From: Thomas Callaway
Sent: 04 March 2015 14:21
To: Planning.Responses
Subject: RE: Planning Consultation on: EG/98/14/PL

Engineers comments in respect to surface water drainage:

APPLICATION NO: EG/98/14/PL

Description of Works: Construction of 3 No. two storey detached houses with new access.

Scale	1:200	At original	A1
Drawing Number	1578/P/D1.2	Revision	-

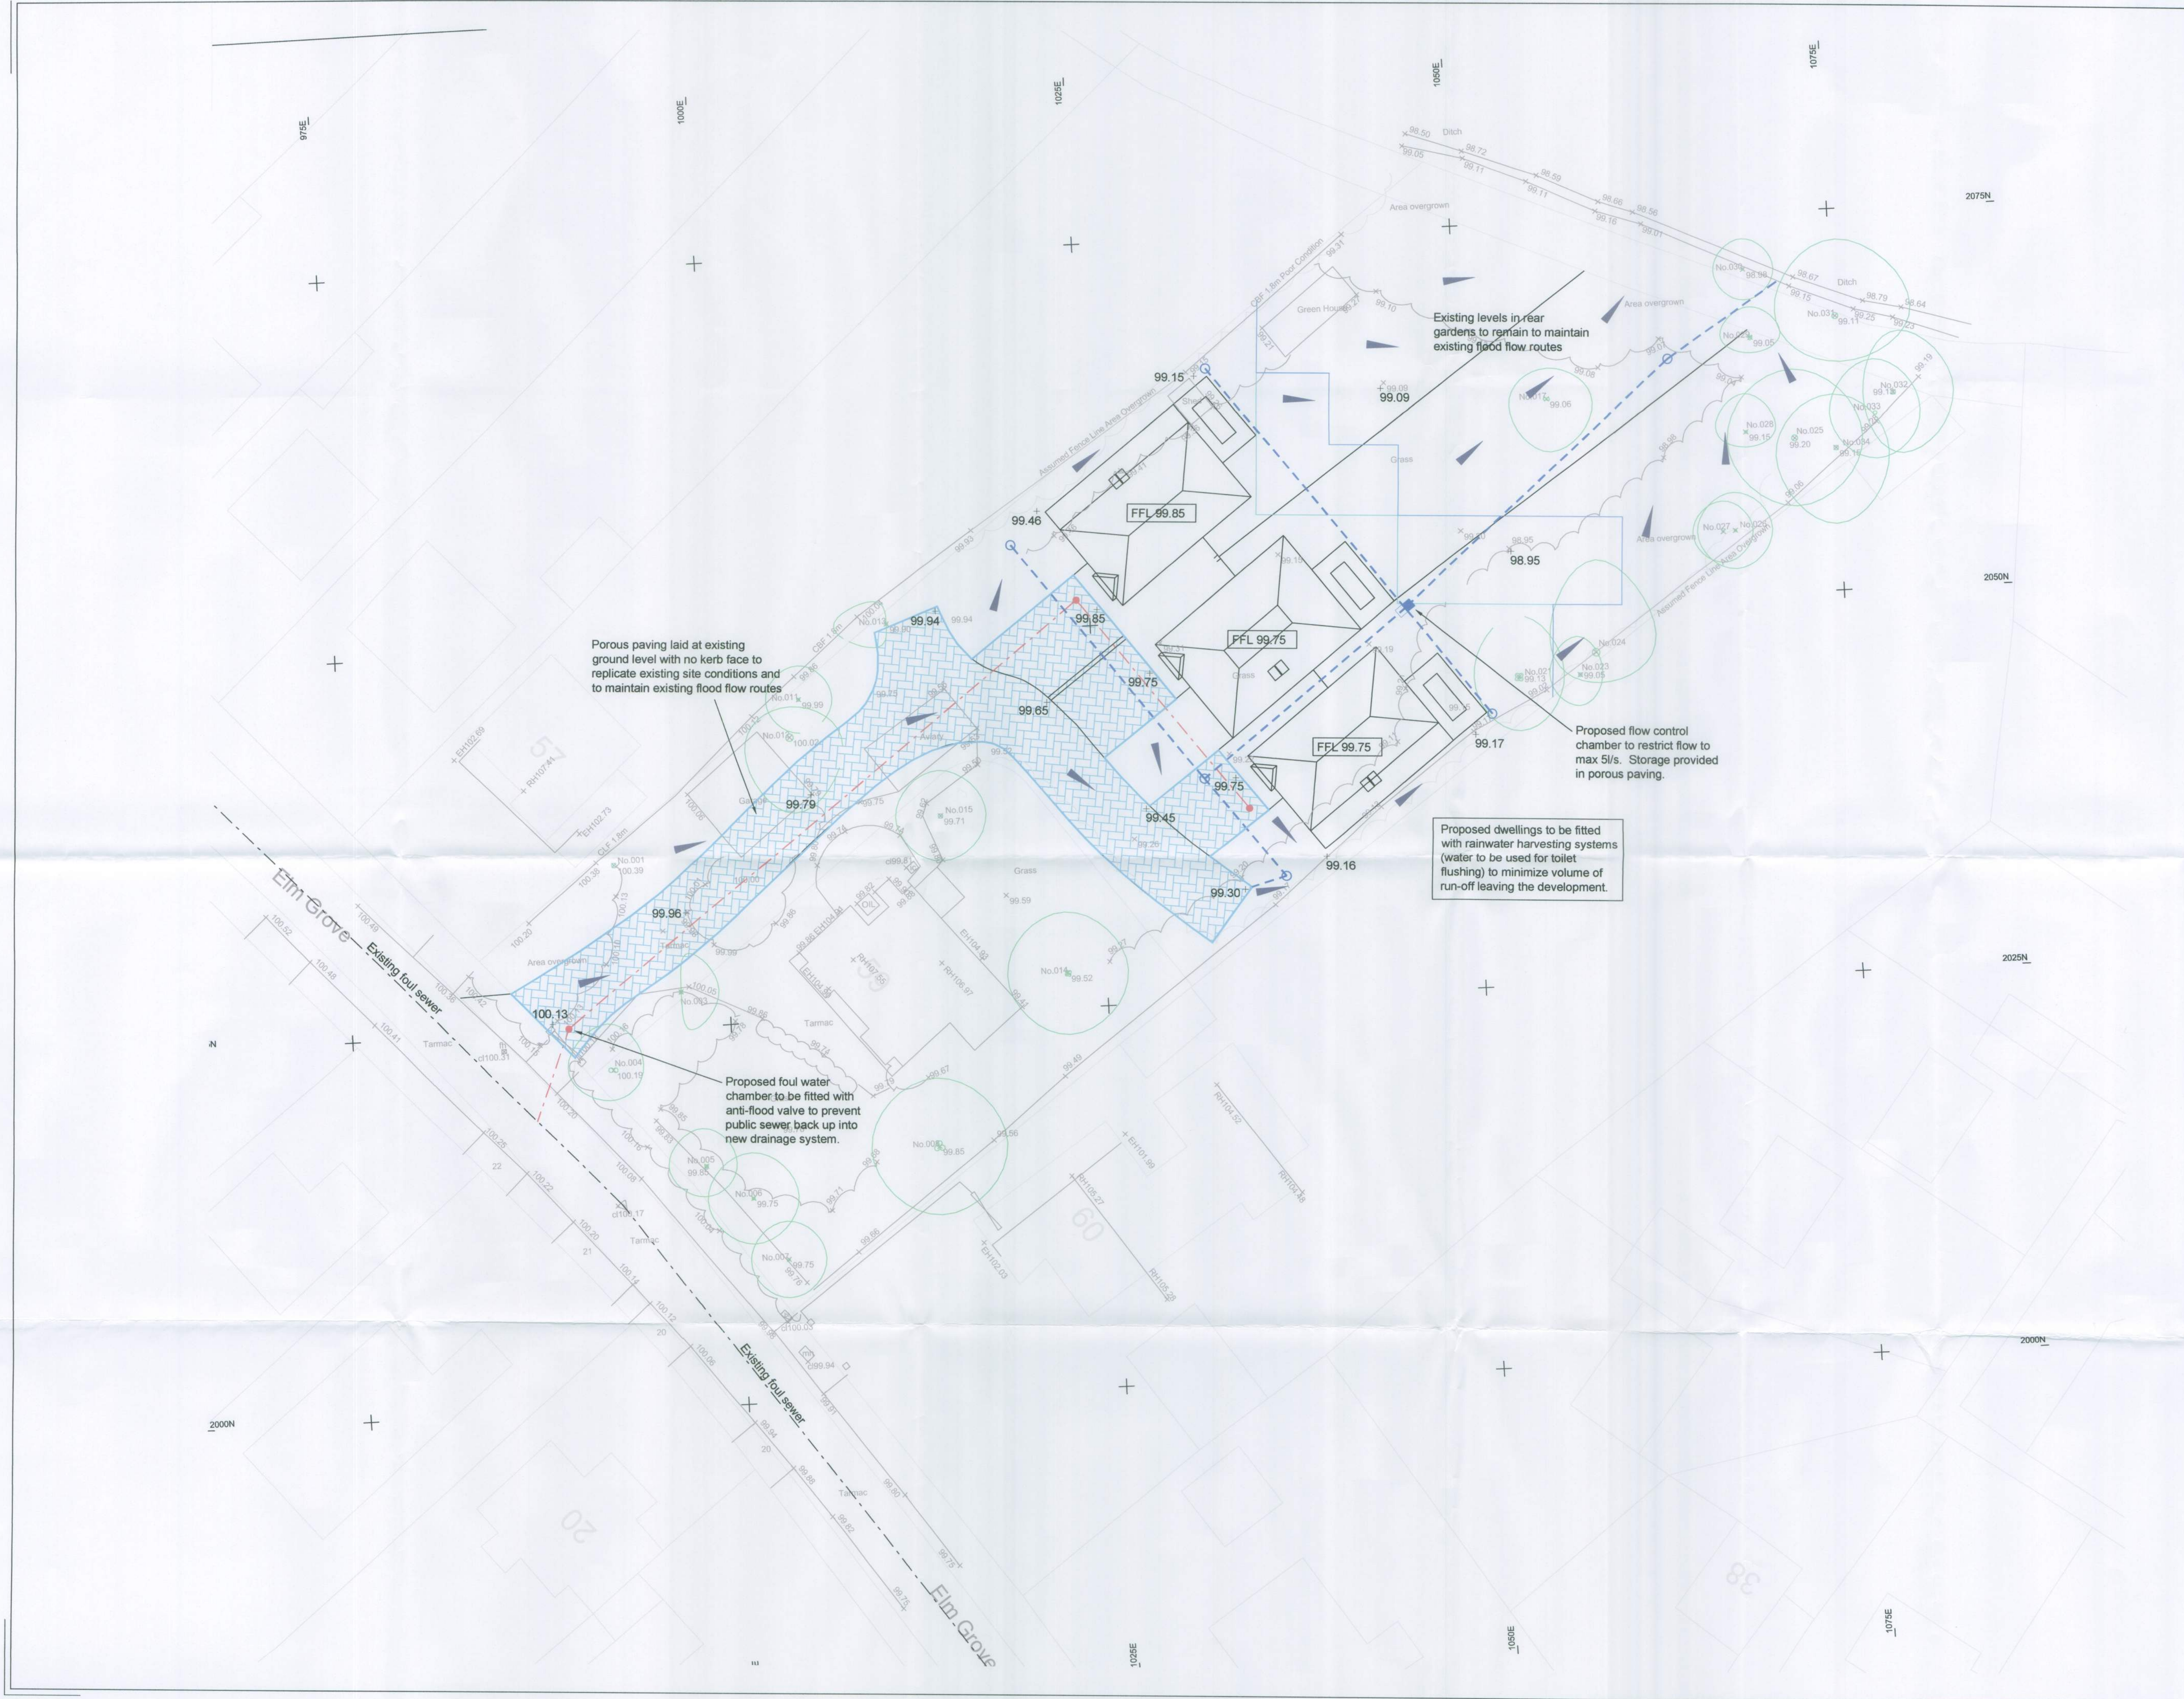
The applicant states that surface water will be discharged to permeable paving, with restricted discharge to the watercourse. The proposals ensure that the buildings remain out of the Flood Zone.

Infiltration rates for soakage structures are to be based on percolation tests undertaken in the winter period and at the location and depth of the proposed structures. The percolation tests and design must be carried out in accordance with BRE 365, CIRIA R156 or a similar approved method and cater for the 1 in 10 year storm between the invert of the entry pipe to the soakaway, and the base of the structure. It must also have provision to ensure that there is capacity in the system to contain below ground level the 1 in 100 year event plus 30% on stored volumes, as an allowance for climate change. Adequate freeboard must be provided between the base of the soakaway structure and the highest recorded annual groundwater level identified in that location.

Any SuDS or soakaway design must include adequate groundwater monitoring data to determine the highest winter groundwater table in support of the design. The applicant is advised to discuss the extent of groundwater monitoring with the Council's Engineers. Supplementary guidance notes are also enclosed for information.

If discharge to the watercourse is still required, it is to be agreed with the EA as it is Main River. The levels should ensure that surface water can discharge for the range of water levels in the watercourse at this location.
